FAO Mr Victor Grayson,
Kirklees Planning Service,
Civic Centre 3,
PO Box B93,
Huddersfield,
HD1,2JR.

Re Planning Application 2024/62/93458/E

I would register an Objection to the above application for development off Cumberworth Lane Denby Dale; application 2024/62/93458/E being but the most recent referencing some portion of land between Leak Hall Lane and Cumberworth Lane headlined previously in public media, 'Disasterous Denby Dale planning saga continues.....'. Whilst readily acknowledging significant difference of the application currently under consideration and the rejected 2024/92168, of which the Authority may retain some record of my objection and comments, in my view there remain important deficiencies including some commonalities.

SITE SECTION AA
1:500

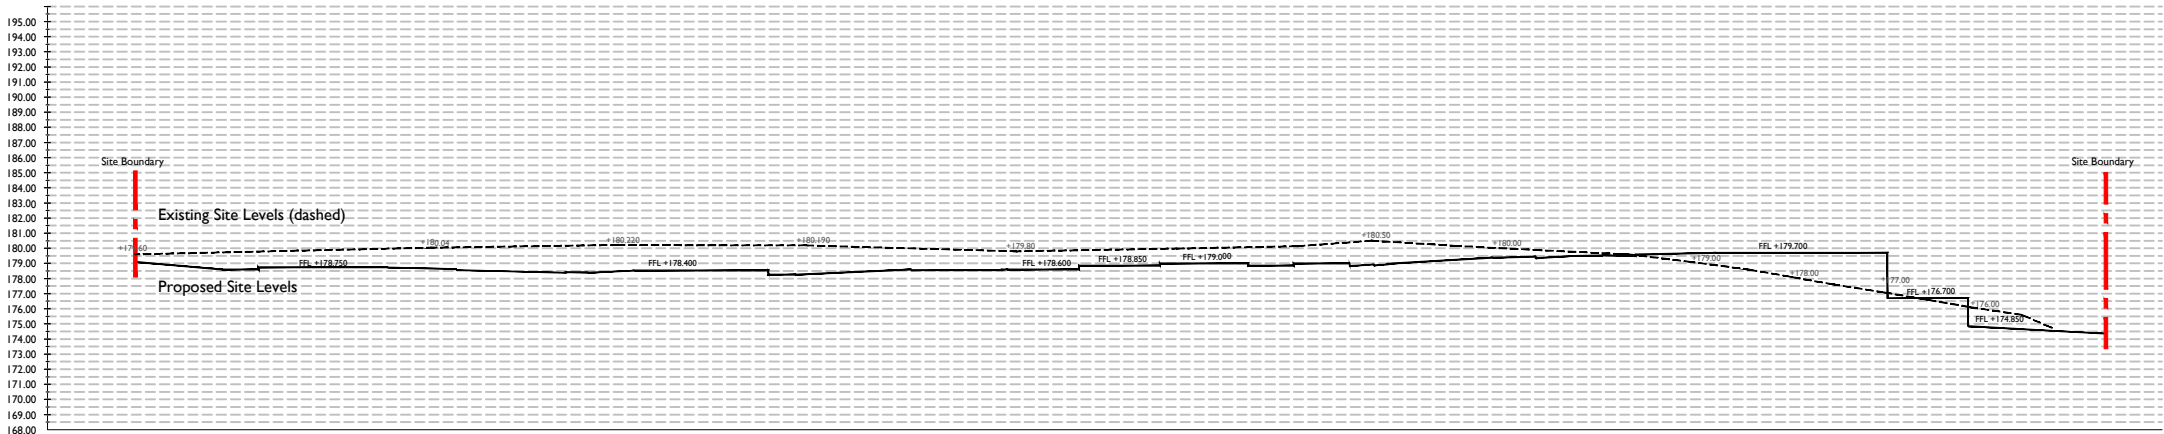
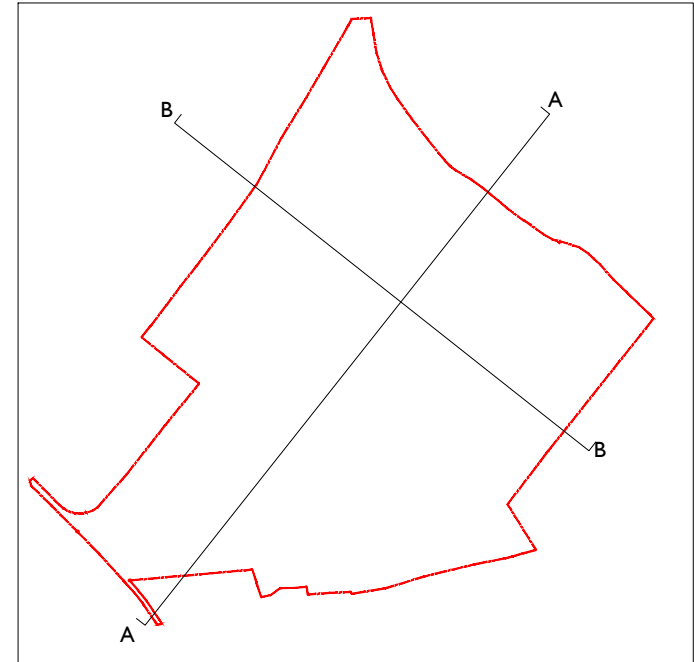
4. There is no explanation of changes in site levels and their implications for existing properties near the site. Surely, construction for example of a twelve metre high property on a three/four metre embankment within twenty metres of an existing dormer bungalow may impact on light and garden privacy, which may have become customary over time. There would seem to be implications for at least one block of the proposed development. I suggest it is scarcely credible that a proposal for a three/four metre embankment with

retaining walling necessary to a single dwelling development would be acceptable if , thereby, it raised by almost the height of a single storey the base level of the proposed development above existing adjacent property.
